OAKLANDS FARM SOLAR LIMITED

NOTICE OF APPLICATION TO MAKE A NON-MATERIAL CHANGE TO THE FOLLOWING DEVELOPMENT CONSENT ORDER:

THE OAKLANDS FARM SOLAR PARK ORDER 2025 (SI 2025/739) AS CORRECTED BY THE OAKLANDS FARM SOLAR PARK (CORRECTION) ORDER 2025 (SI 2025/1070)

Drawing Title
**Drakelow Access
Detailed Cross Section**

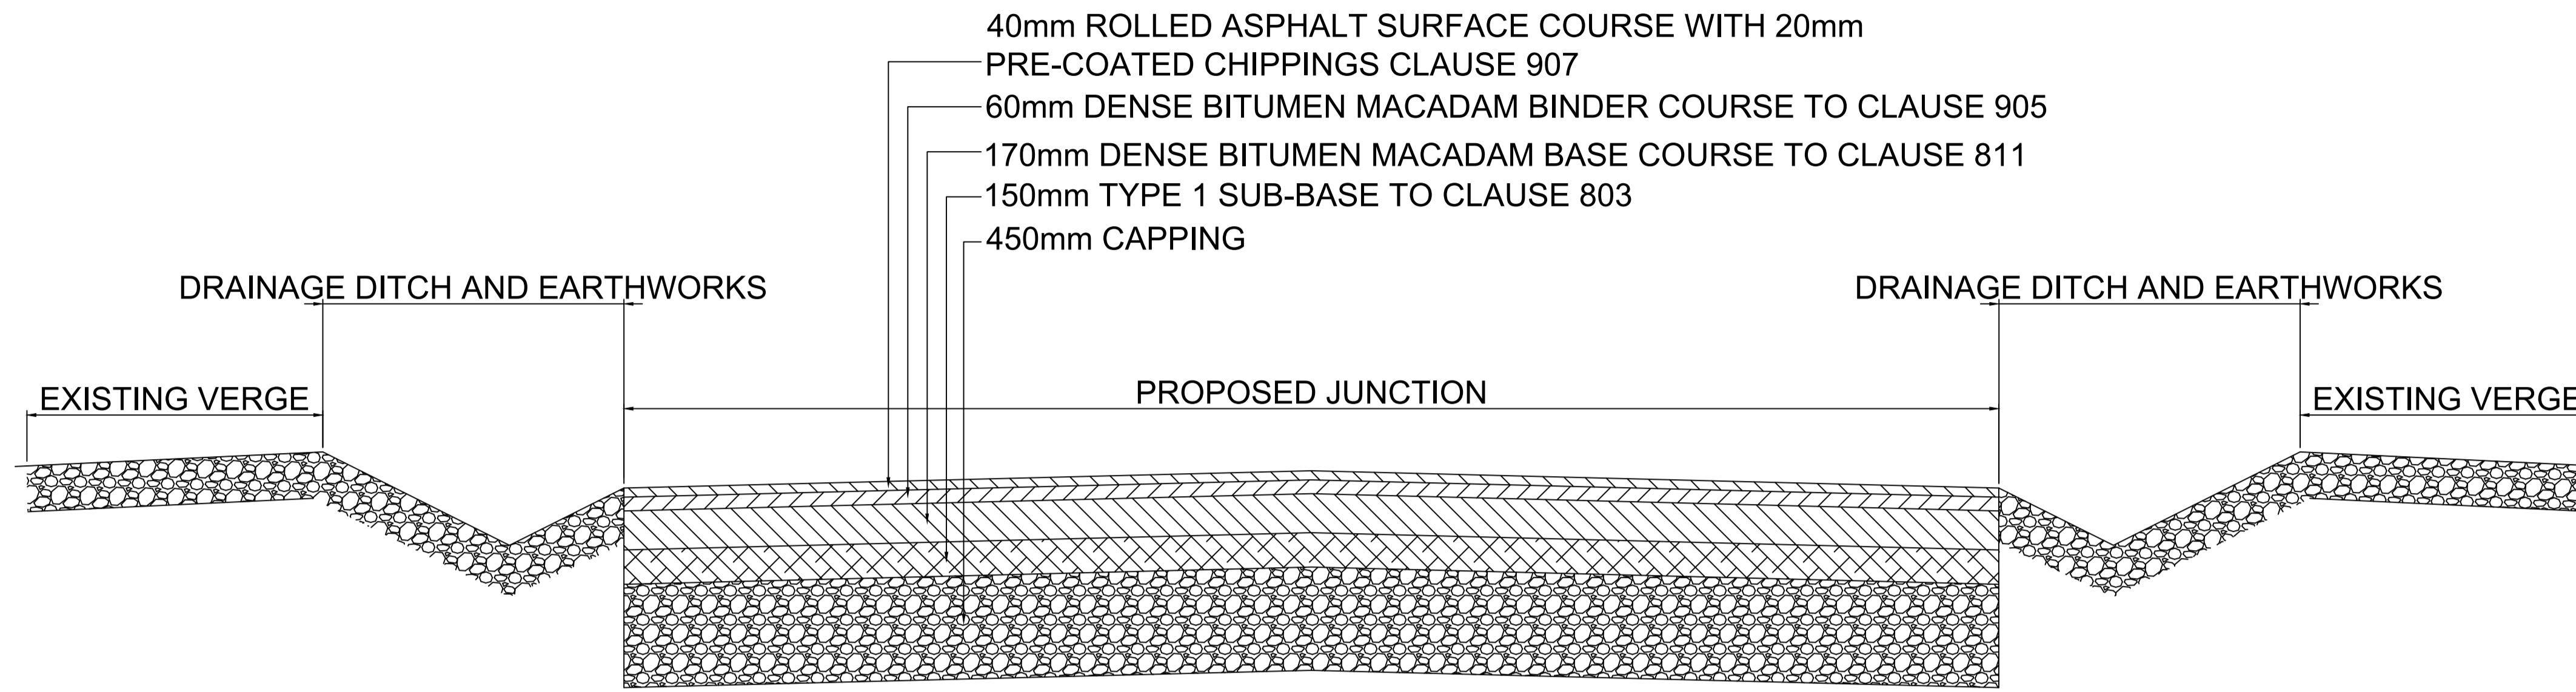
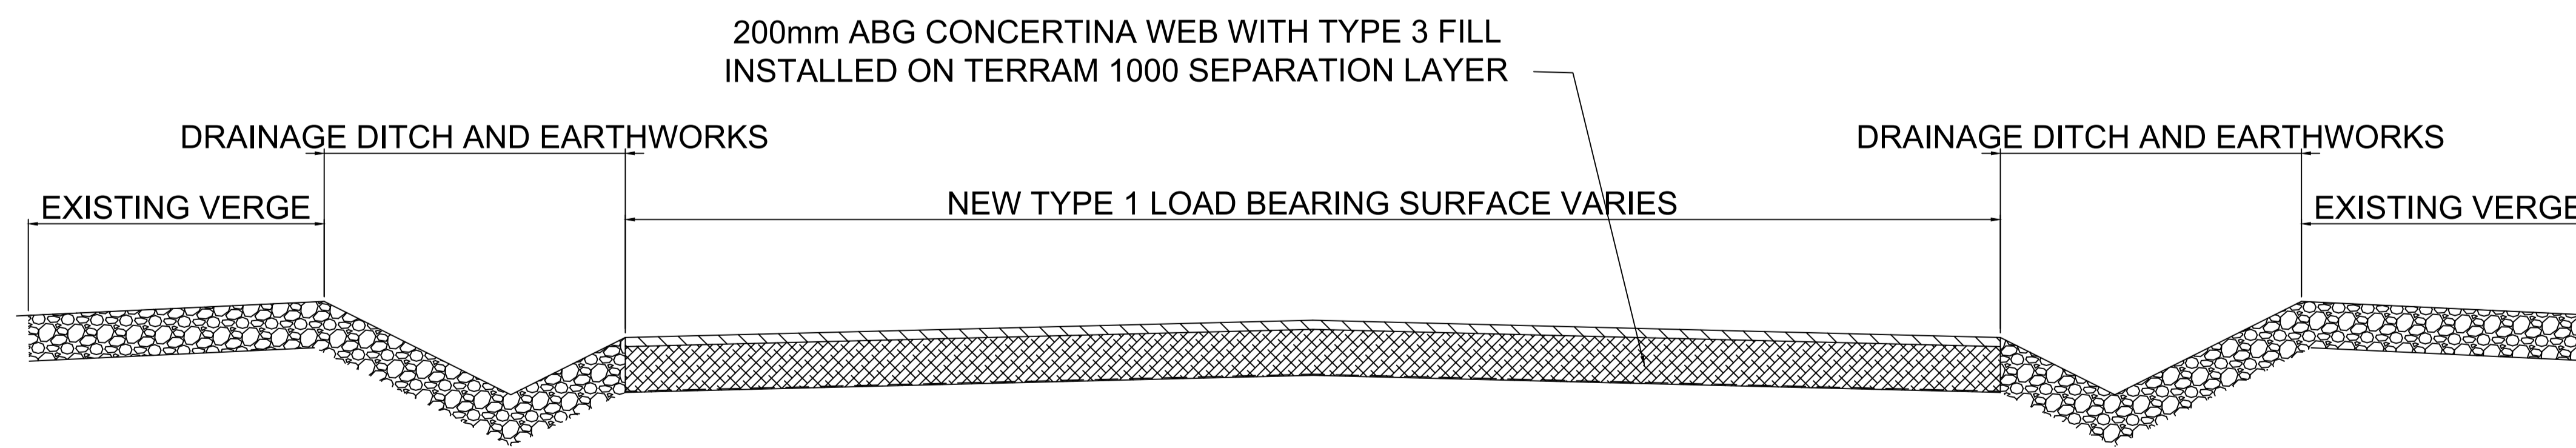
Change 7 – Permanent Internal Access Tracks

Currently the parameters allow for a permanent access track of 3.5 – 6.0m wide made up of 200mm of type 1 compacted stone/gravel with a geotextile membrane, or mown grass corridor. It is now proposed that this is amended to allow up to 400mm of compacted stone/gravel, such as type 1/6F5, with a geotextile membrane, or mown grass corridor. It should be noted that the additional 200mm of the material would be used to build up the road as opposed to requiring further excavation.

EN010122 - D5 - 13.7 - Indicative Cable
Trench Plan

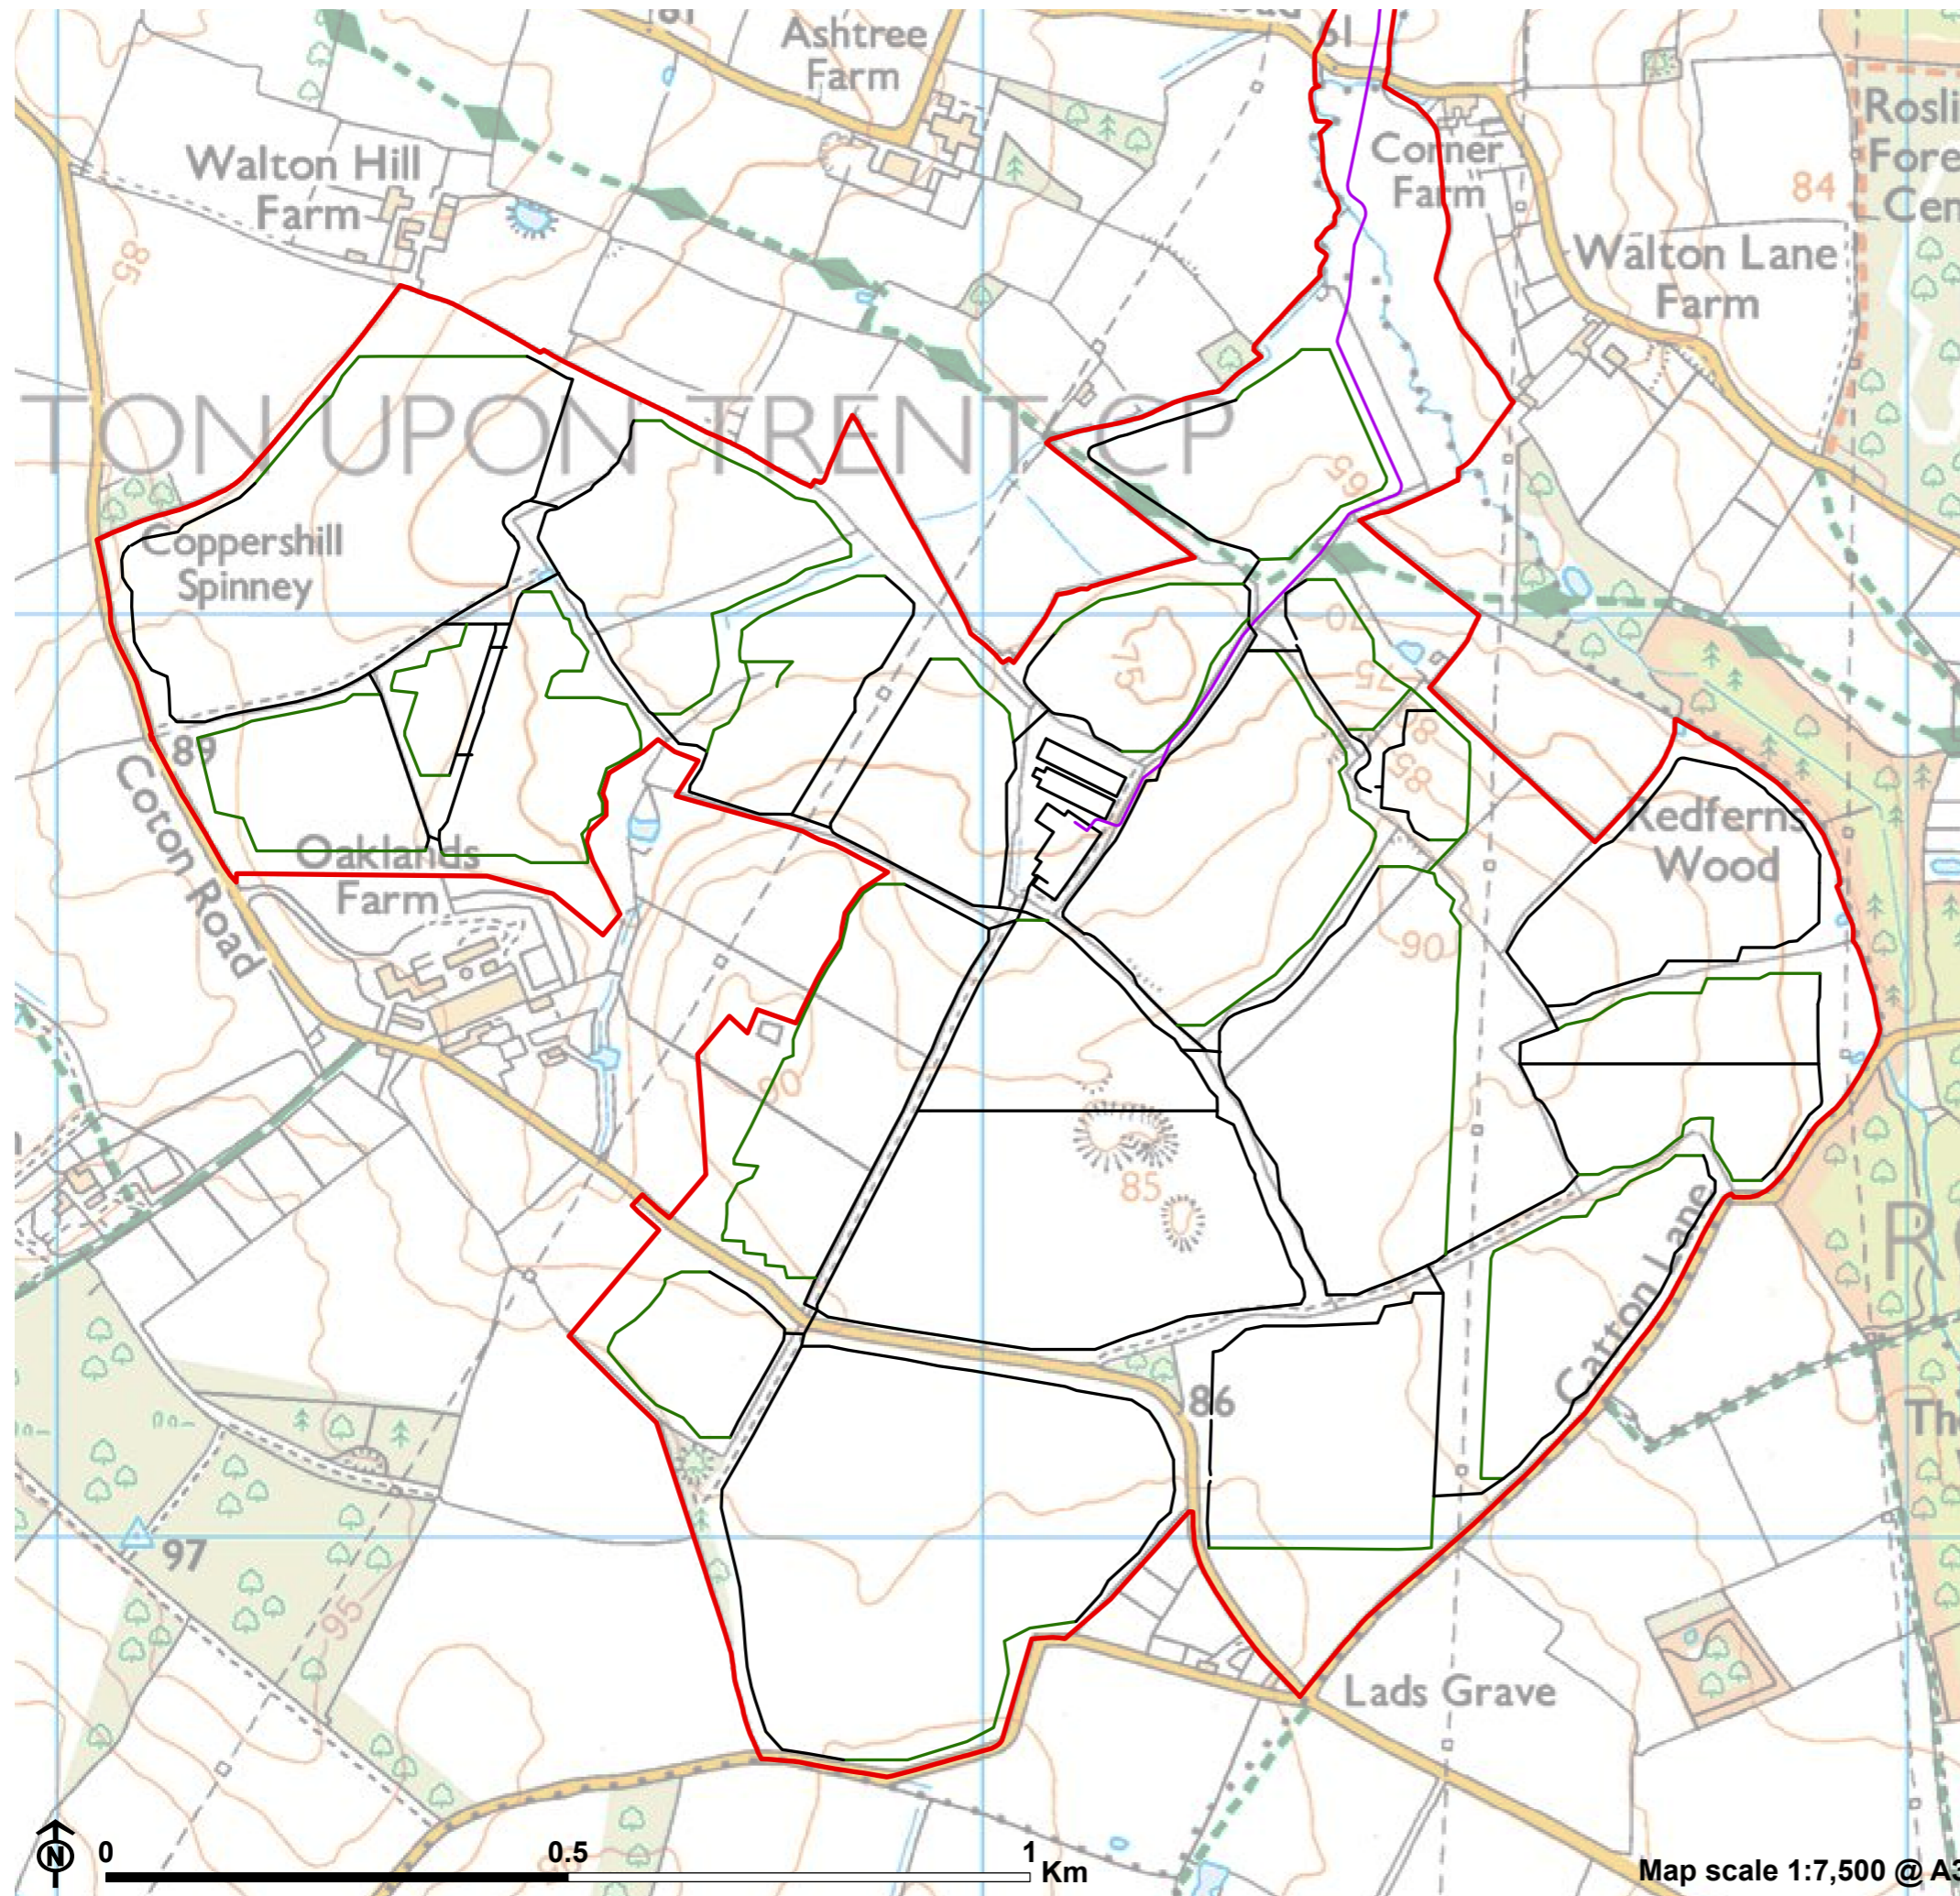
Change 6 – Onsite Cabling

Work no. 7 includes three aspects on onsite cabling:

- between battery containers, Power Conversion System (PCS) units, and from PCS to transformers;
- between the transformer stations and the Proposed Development substation; and
- between PV modules and inverters and from inverters to transformers.

The parameters allowed for a minimum cable depth of 0.9m and a maximum cable trench dimension of 1.5m wide and 1.2m deep. It is now proposed that the minimum cable depth would be 0.7m and the maximum cable trench dimension would be 1.8m wide and 1.2m deep. In exceptional circumstances, for example to cross features such as other cables, the trench depth will be specific to engineering requirements.
